From: Biazar, Shahab
Sent: Friday, January 10, 2014 4:27 PM
To: "Jon Niski" (JNiski@tierrawestllc.com)
Cc: Sims, Timothy E.
Subject: Hydrology comment and markup for The 14th East (K13/D50)
Attachments: K13D050_shahab_markups_2014JAN10.pdf

Attached please find markups for the grading and drainage plan for The 14th East (K13/D050)

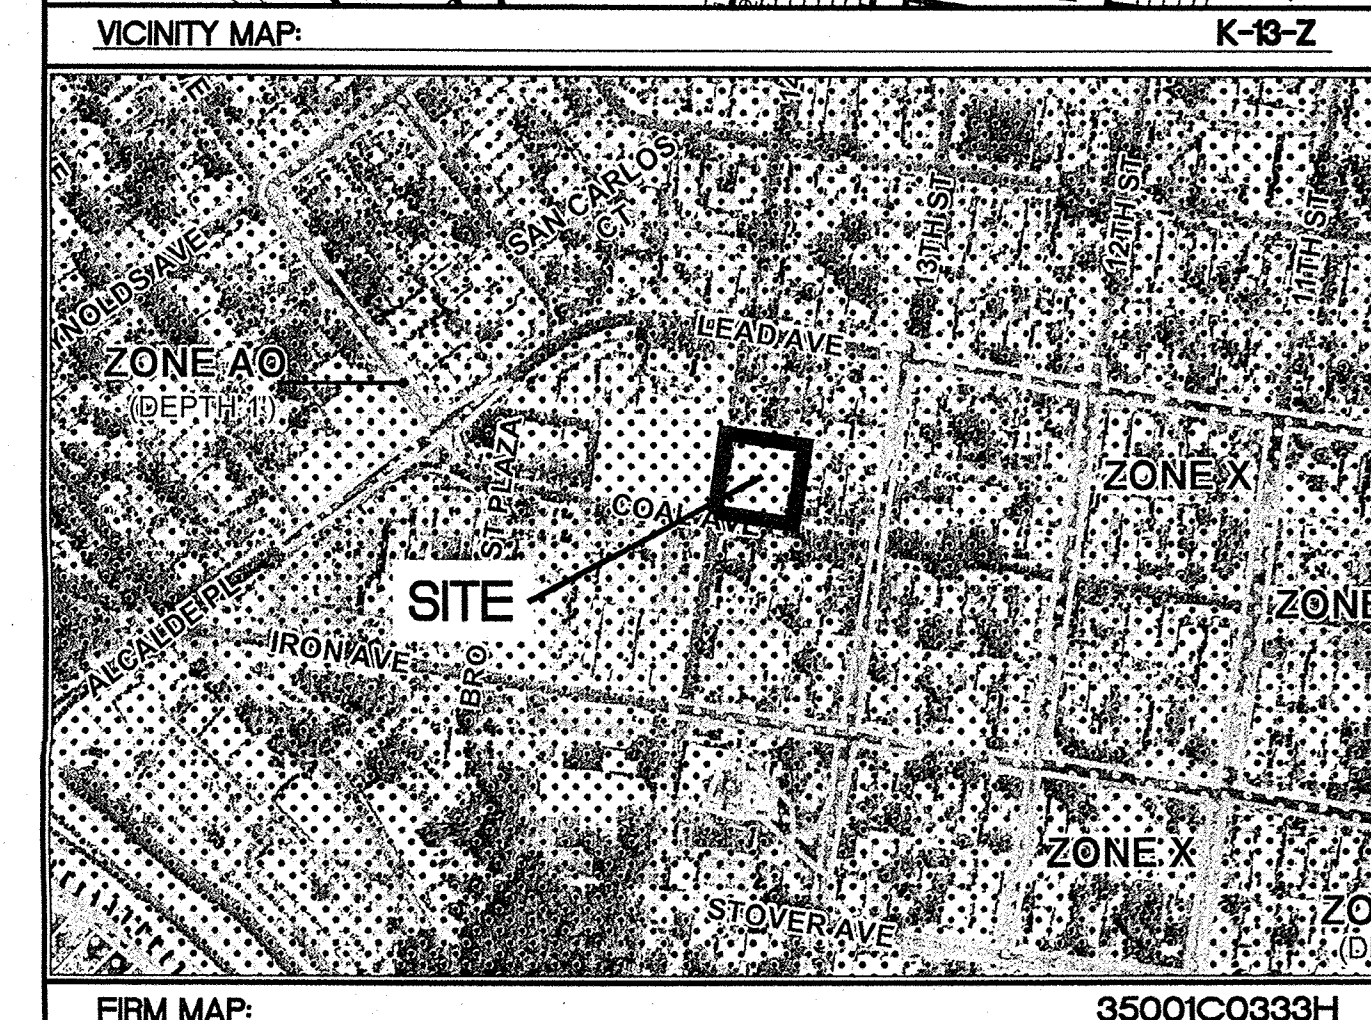
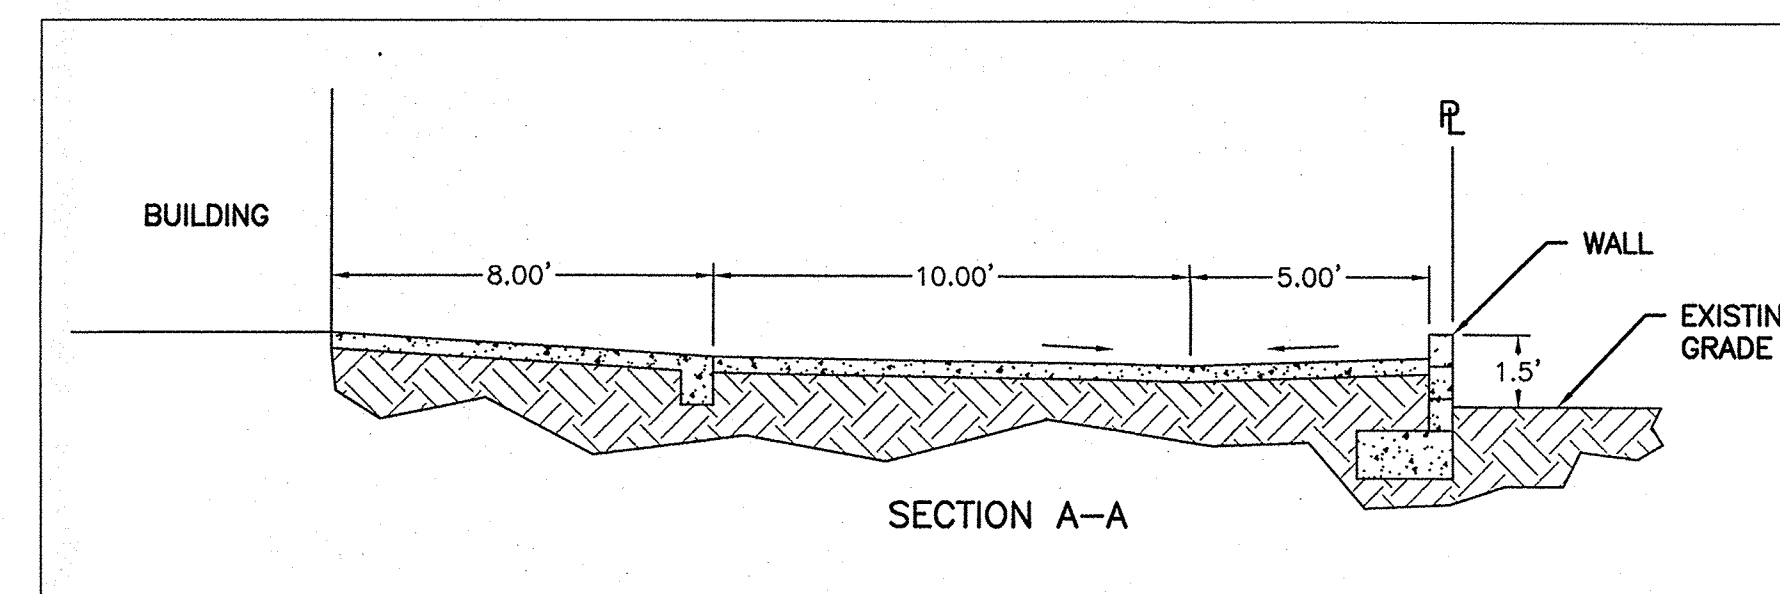
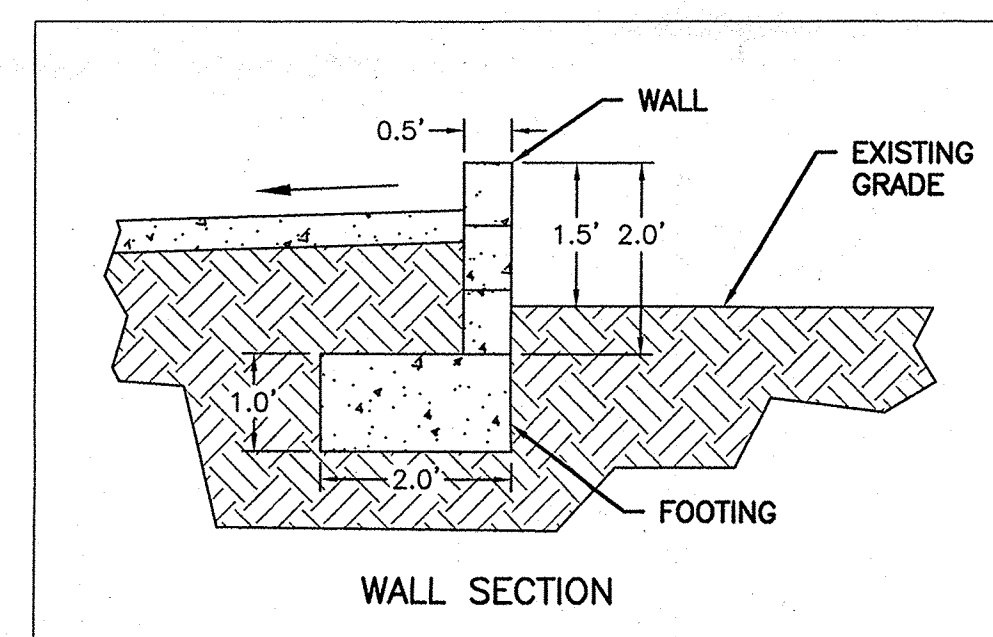
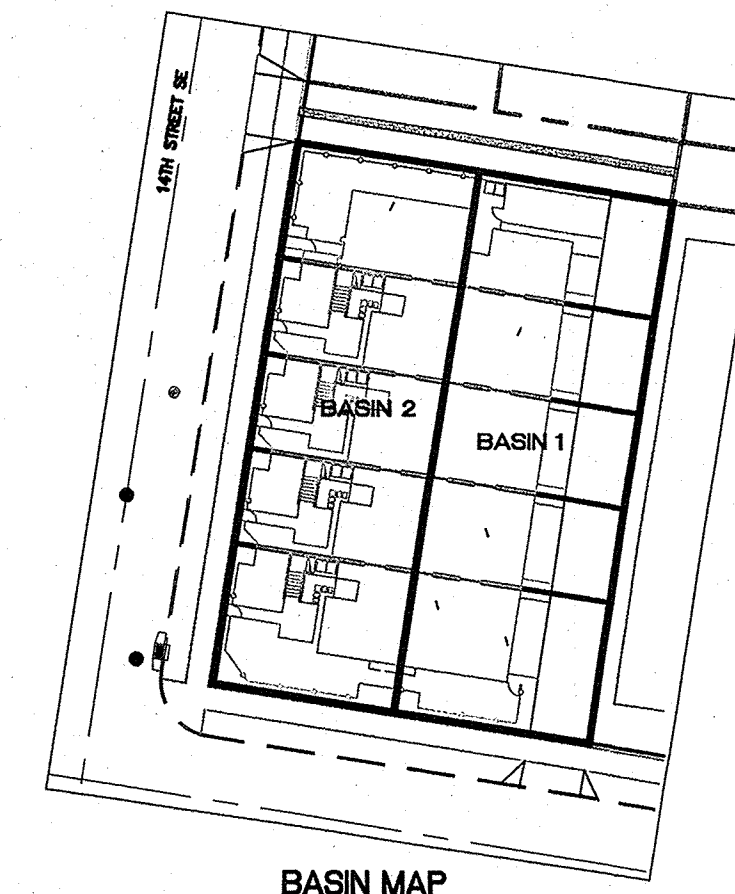
- _ Depress all the landscaping areas where possible (6" min.).
- _ All the driveway not used should be removed and replace with standard curb and gutter.

- _ Provide additional spot elevations along the existing sidewalk on 14th Street to assure ADA requirement are met were new connections are being proposed from the new buildings. Also check the ADA grades at the proposed driveways.

- _ Include the Coal Street name on the Plan and provide a City Bench Mark.
- _ Show more spot elevations along the alley to assure the runoff and gates/entrances are not being blocked with the proposed alley improvements. Show all the existing improvements.

- _ How does the alley drain to the east (Show additional elevations to the east).
- _ Is there any offsite runoff from the east. There are roof gutters from the existing buildings that drain to the west.

- _ Fix Section A-A.
- _ All the removal and replacement of the existing driveways, new driveways/sidewalks, and Alley improvements should be constructed under the City Work order.
